**Subject:** Stormwater Comments Color  
**Page Index:** 1  
**Date:** 5/11/2021 7:51:09 PM  
**Author:** CFurchak  
**Color:** ■  
**Layer:**  
**Space:**  
**Page Label:** [1] 1 CV01

X:\25188\000_00\25188000\FD\Homestead 2 Sand Filter GEC Plans\Drawings\GEC\25188000\10 - SF.dwg, DT02, 3/23/2021 2:54:14 PM, CS

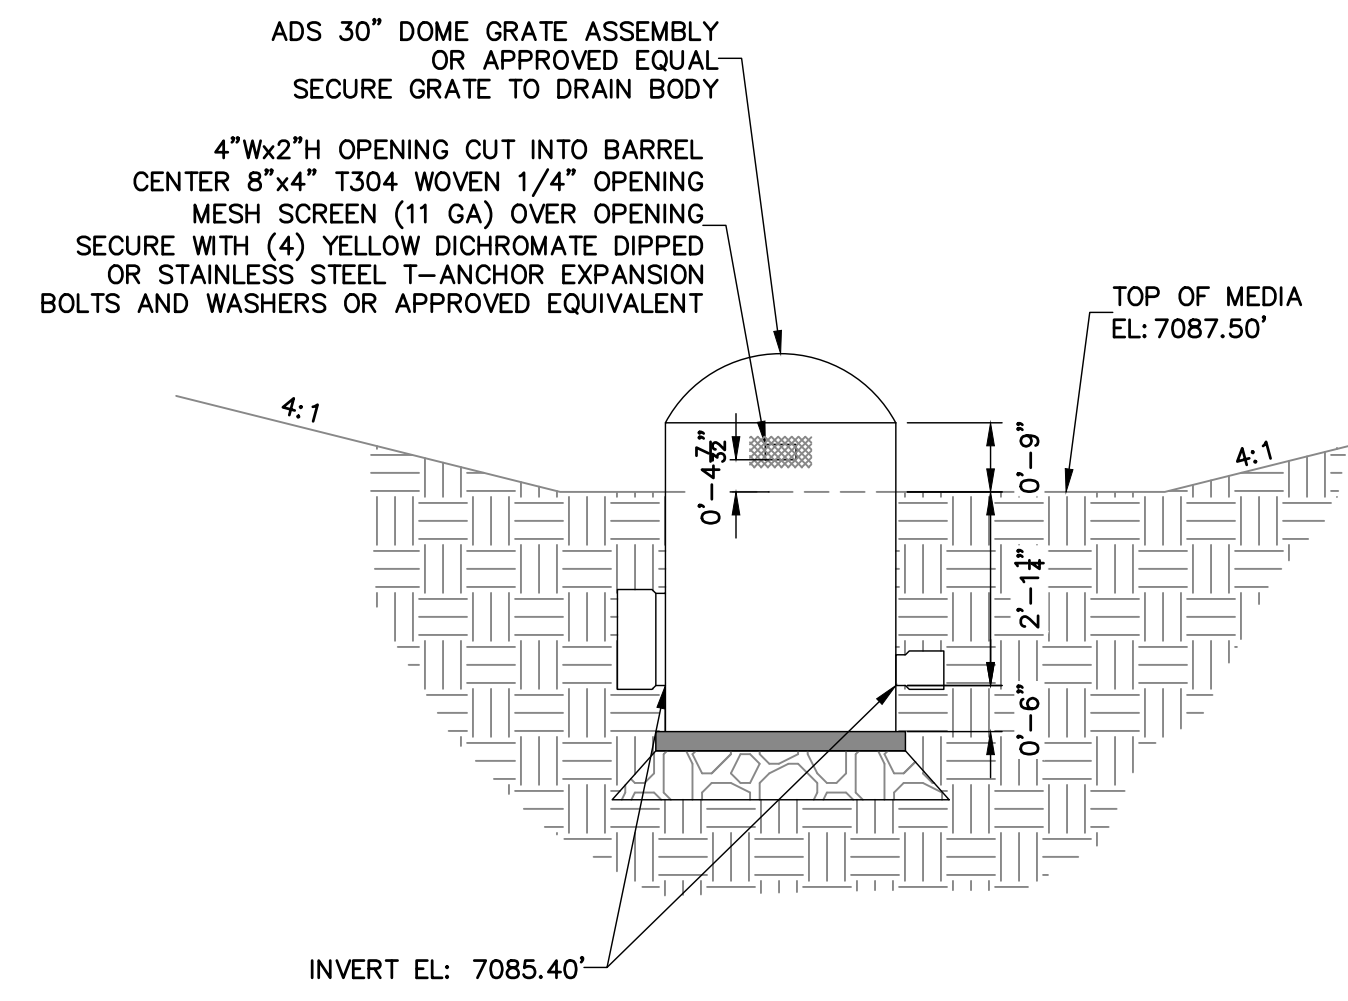
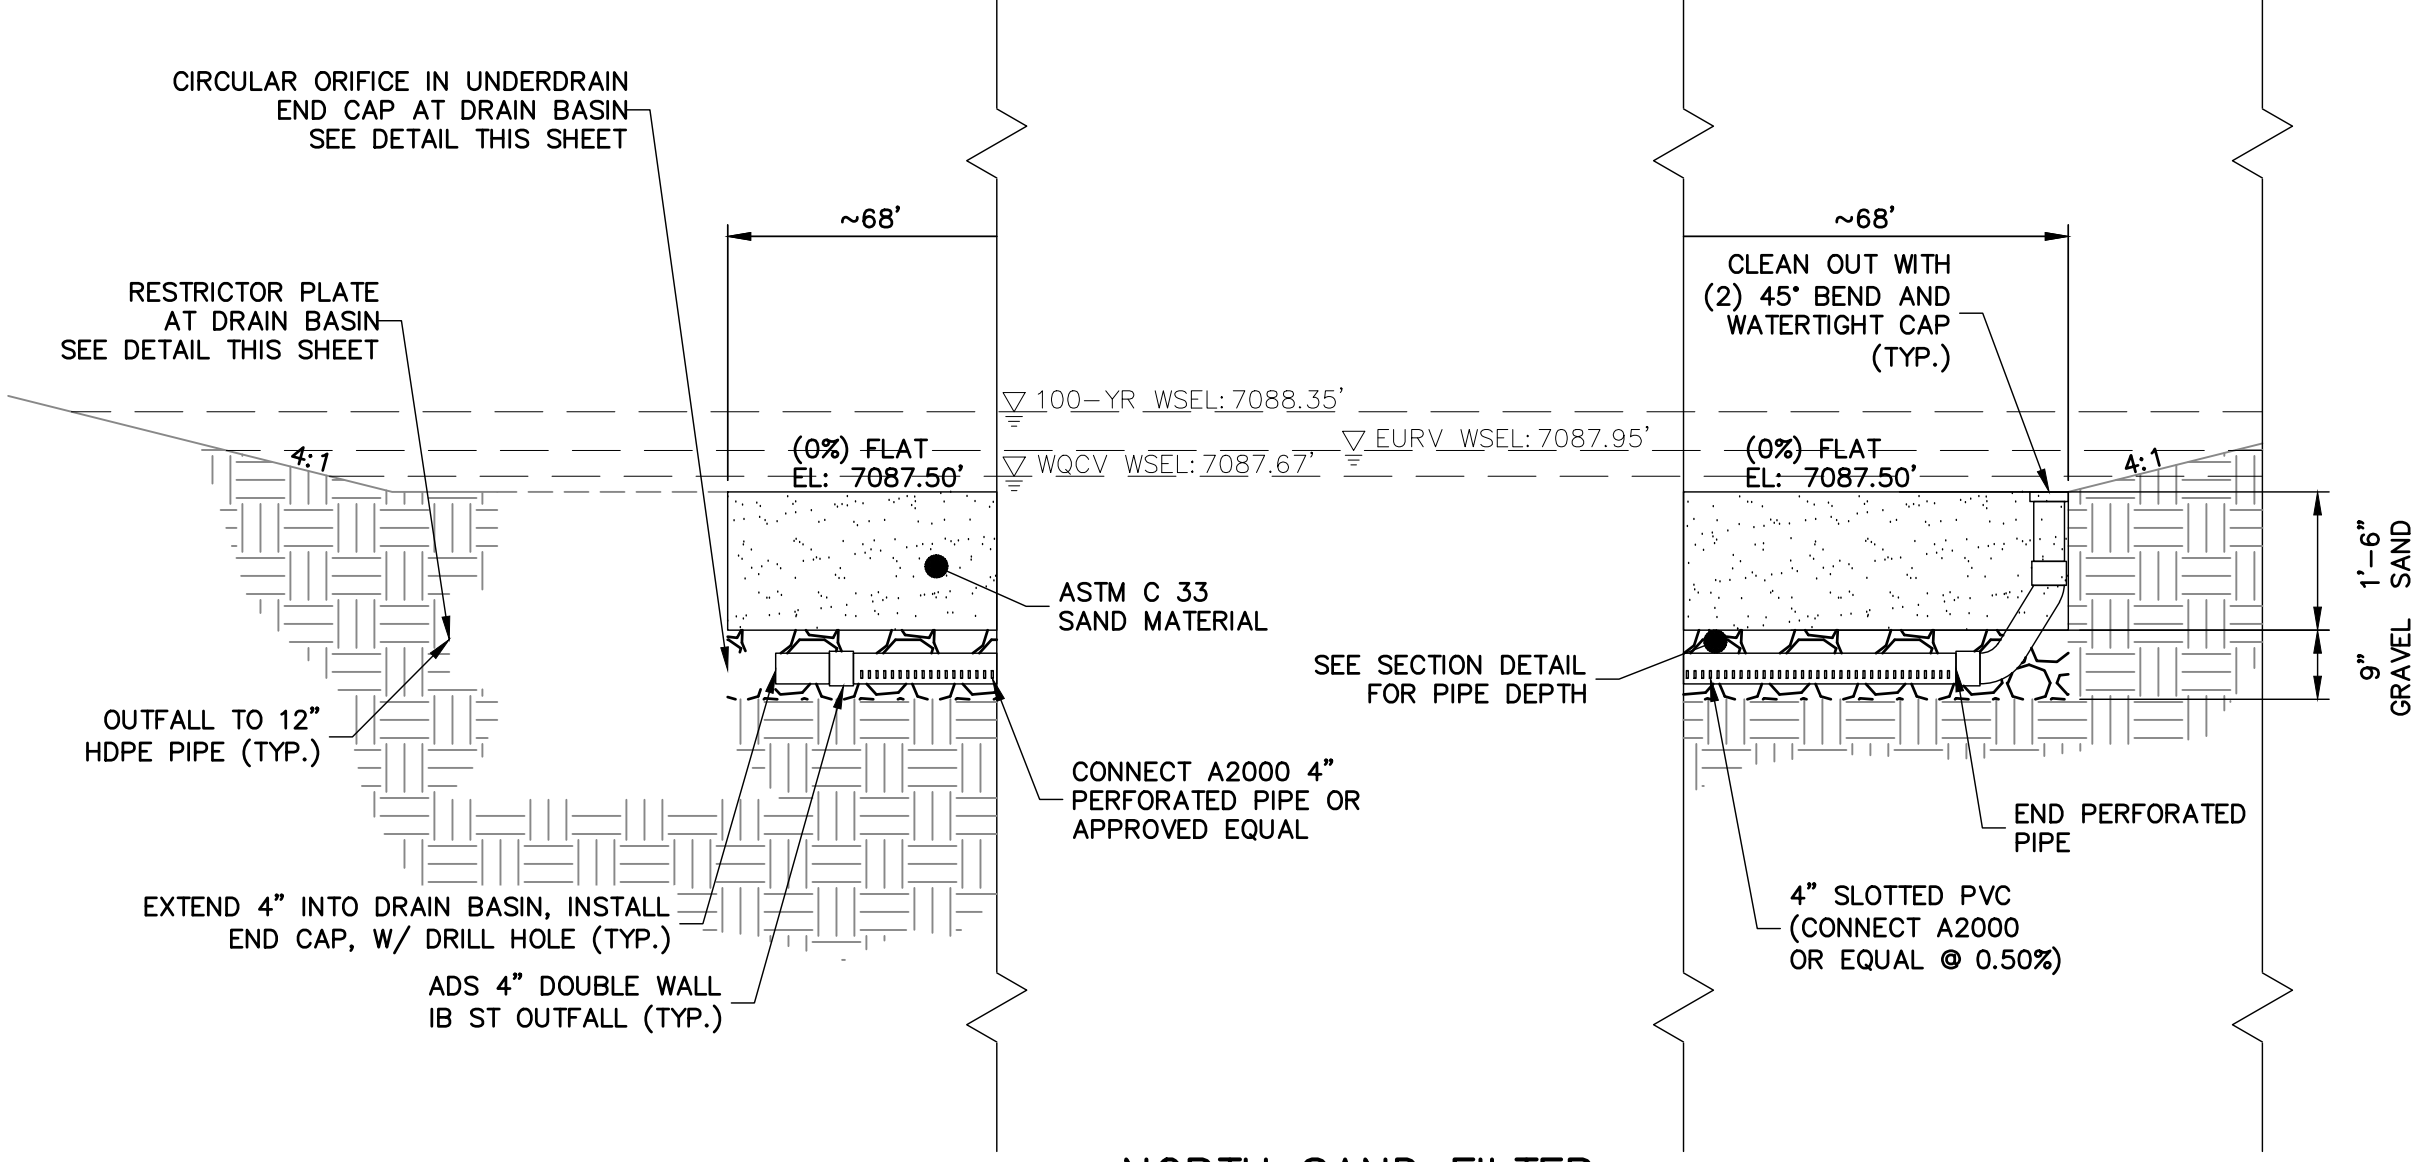
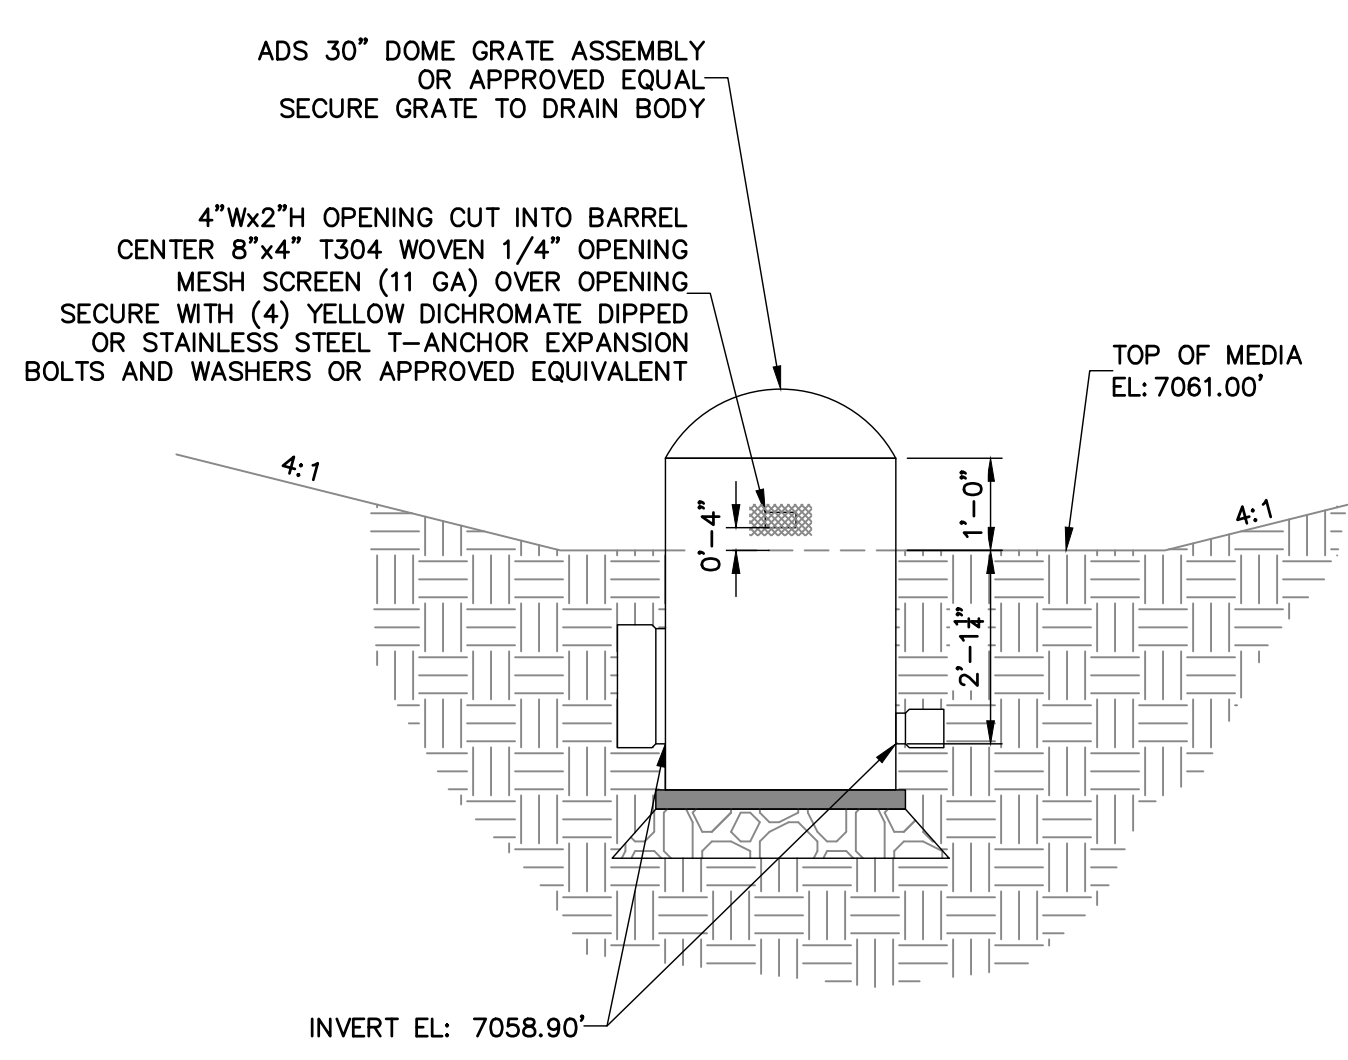
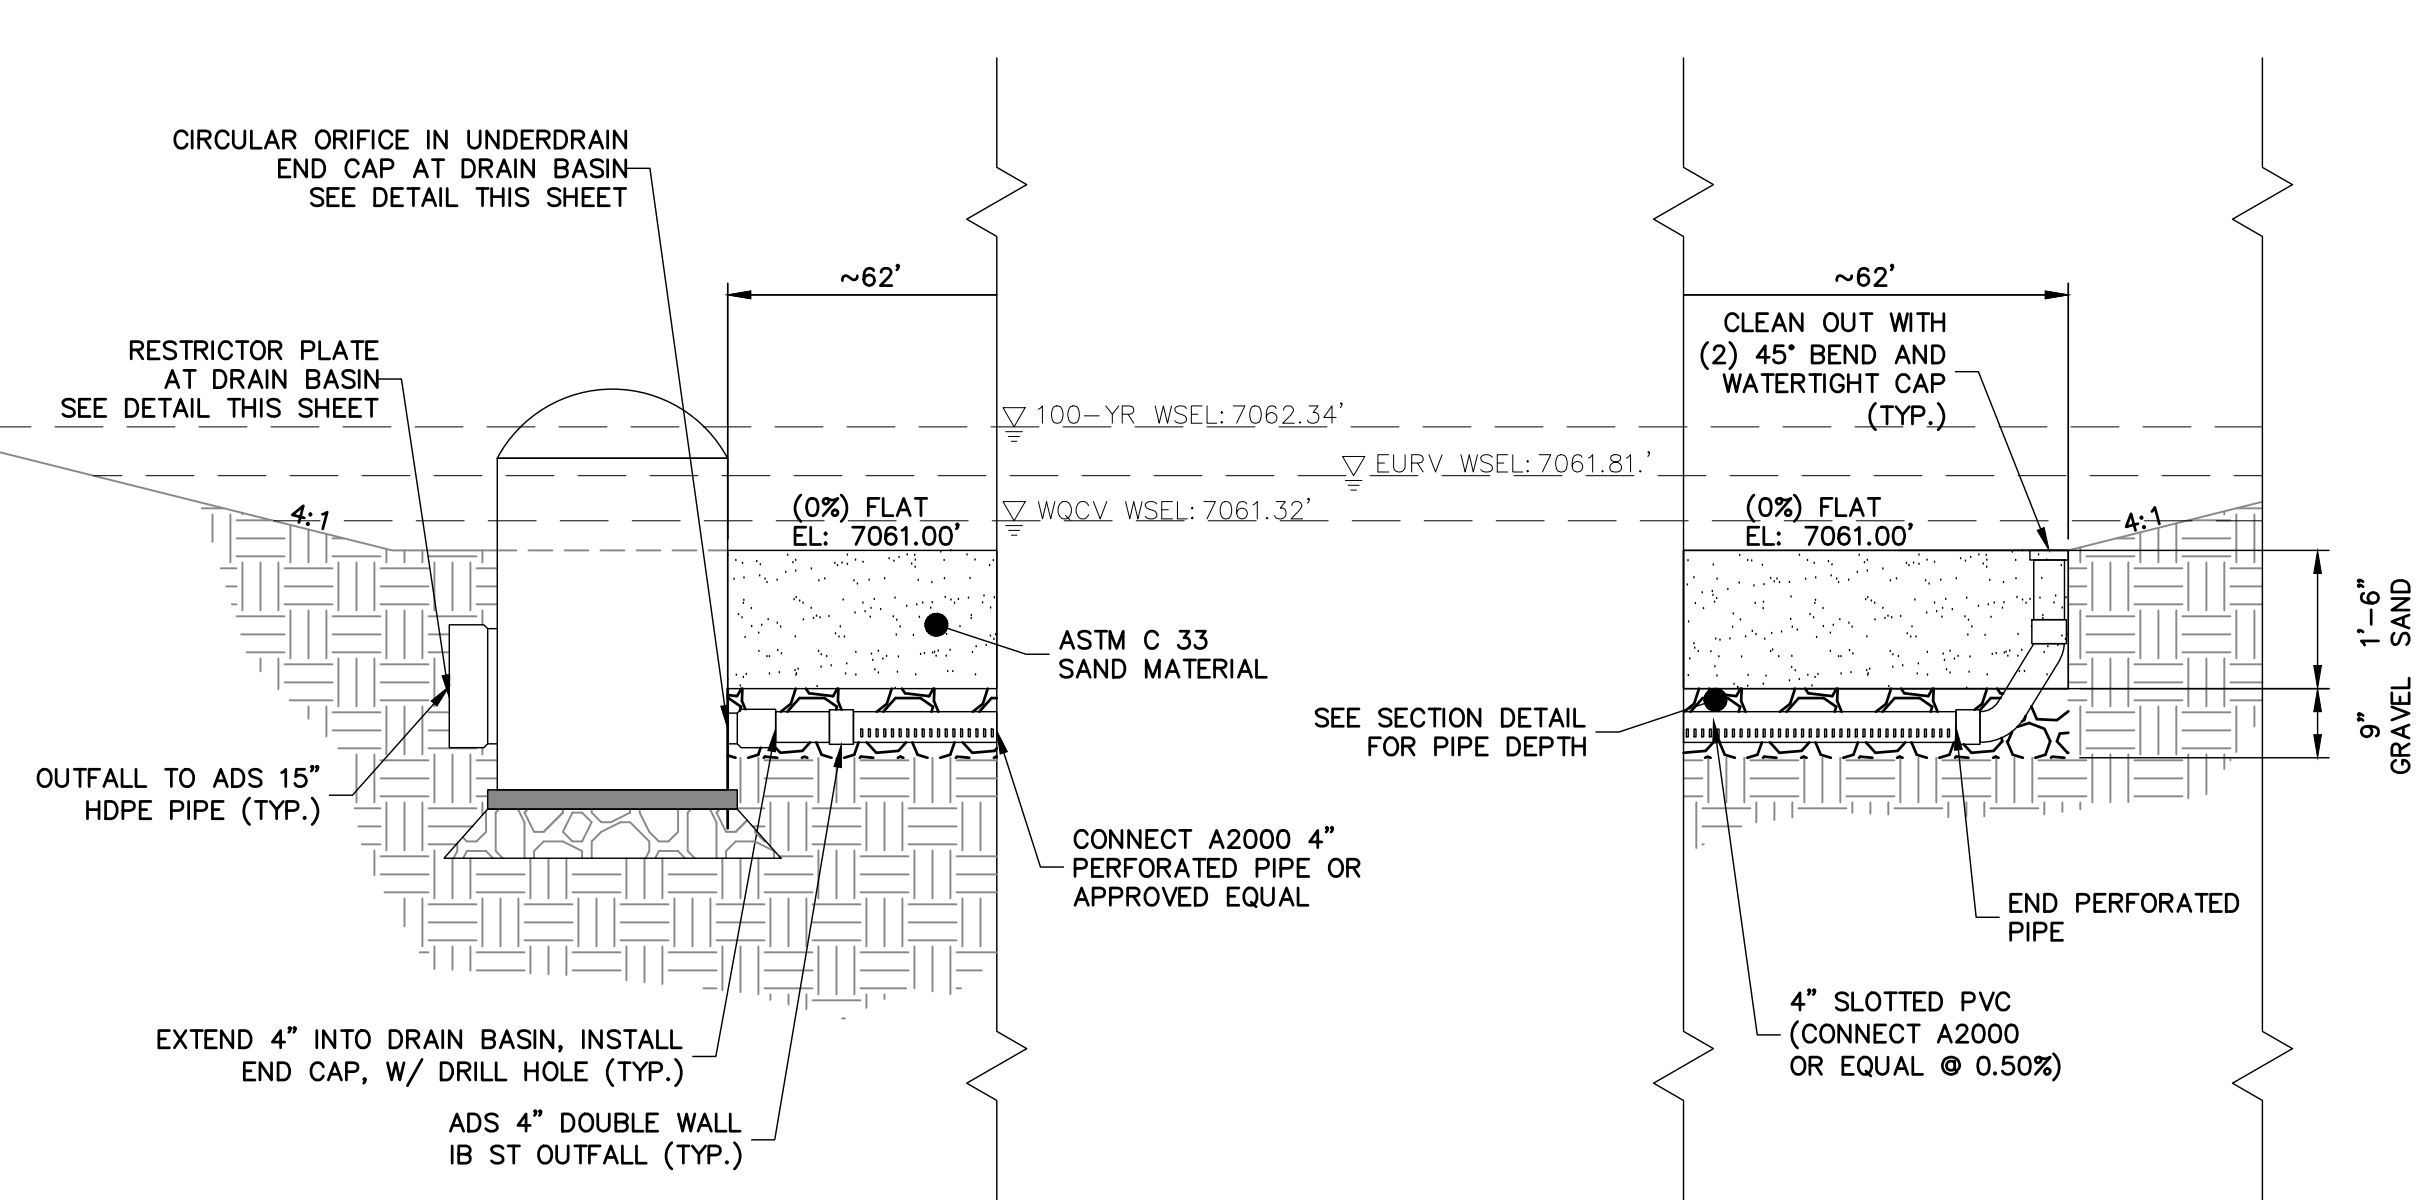
replace with EPC approved VTC detail (VT-1 and VT-2 in DCM Vol. 2, Chap 3.3) or revise to be 75ft min length

IPRAP Provide riprap gradation table and note that CDOT Section 506 Requirements apply

Provide riprap gradation table and note that CDOT Section 506 Requirements apply

provide gradation
